Application No: AW/406/21/PL
Site Address: 16 The Precinct Aldwick PO21 5SB
Description of works: Addition of extraction unit and alterations to shop front to enable change of use under class E.

Thank you for your internet representation made on 5th February 2022 which has been recorded as an objection with the comments as follows:

SITE LOCATION PLAN
AREA 2 HA
SCALE: 1:1250 on A4
CENTRE COORDINATES: 491637 , 99587

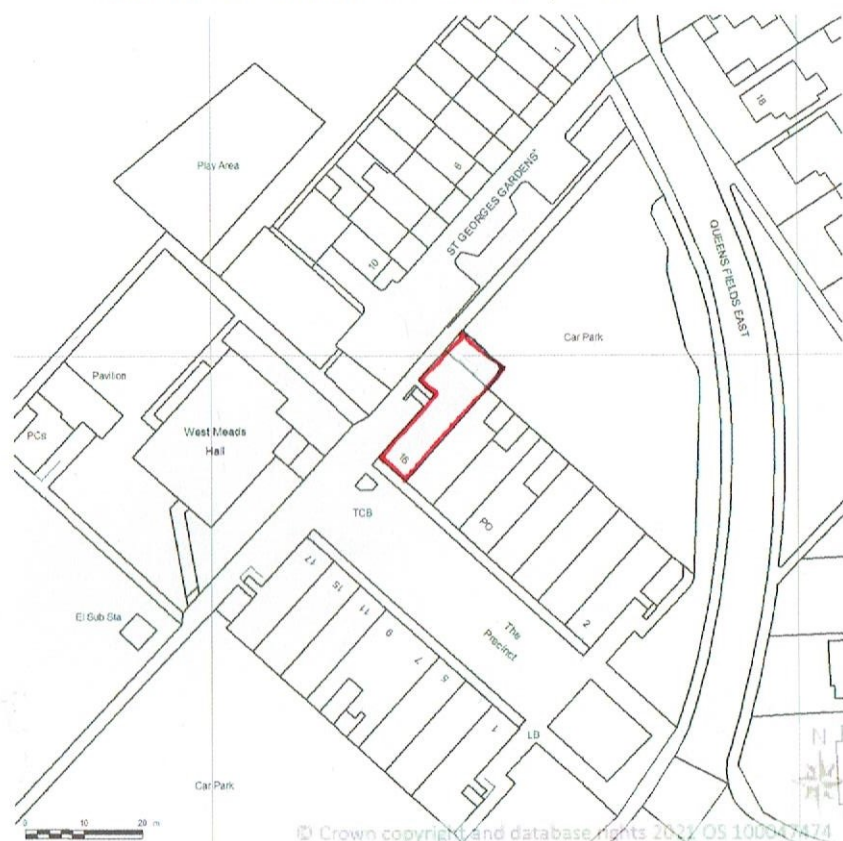
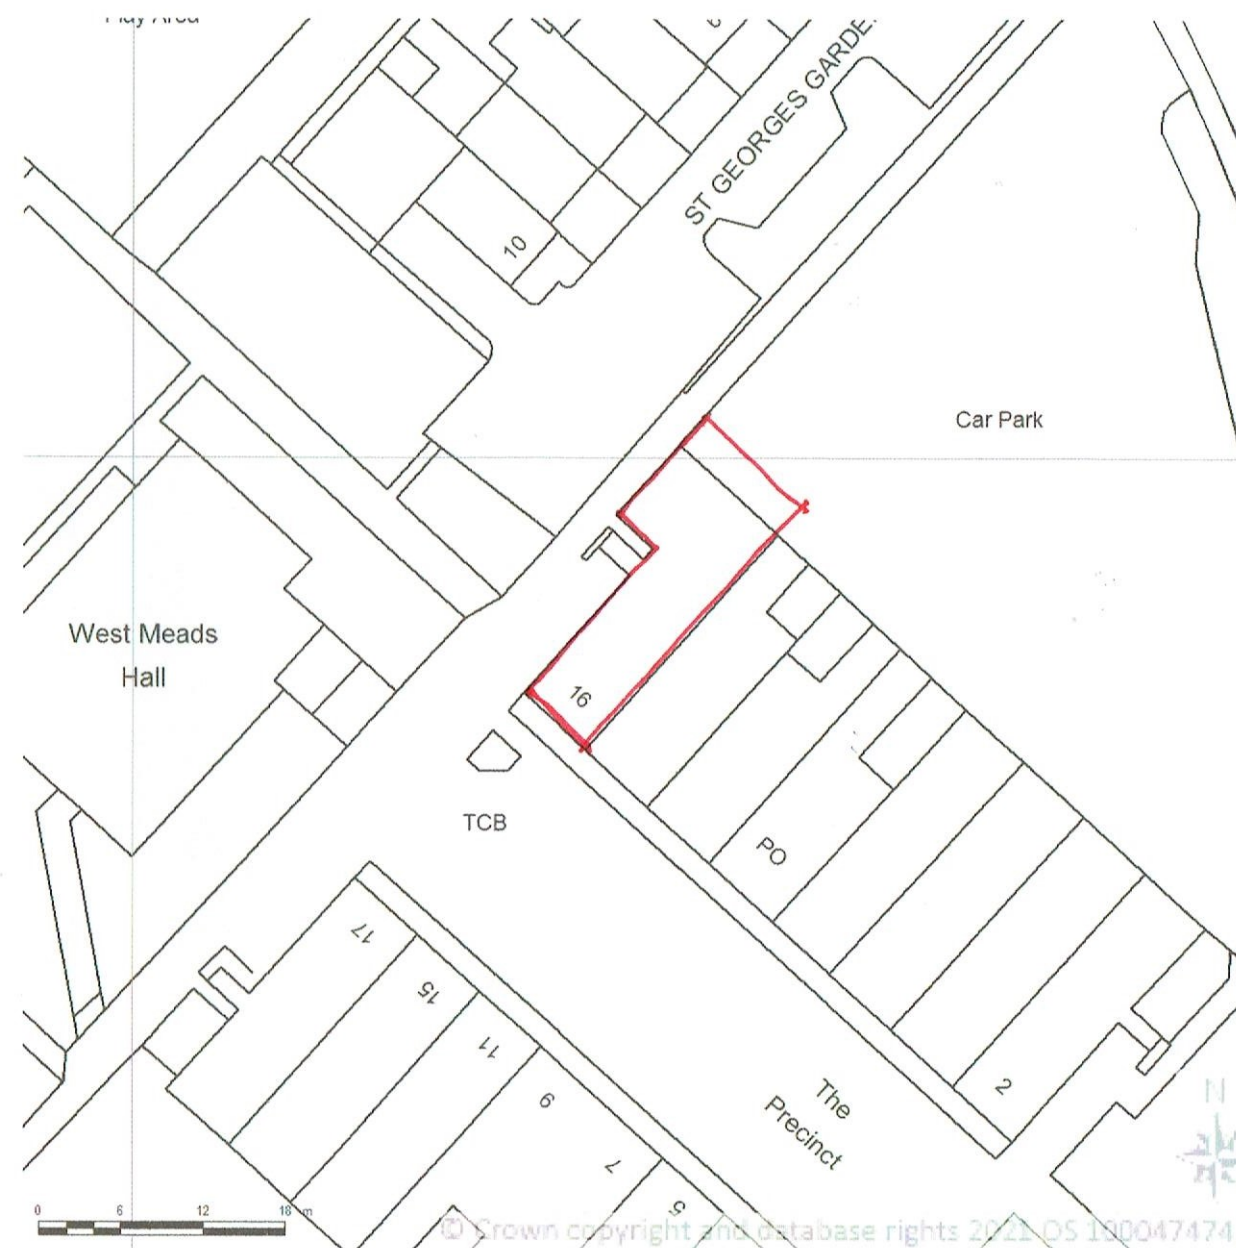
Just reviewed the plans & I'm afraid the location as show on plans submitted is actually the rear of SMR Solicitors at 1 The Precinct and not 16 The Precinct which is on the other side
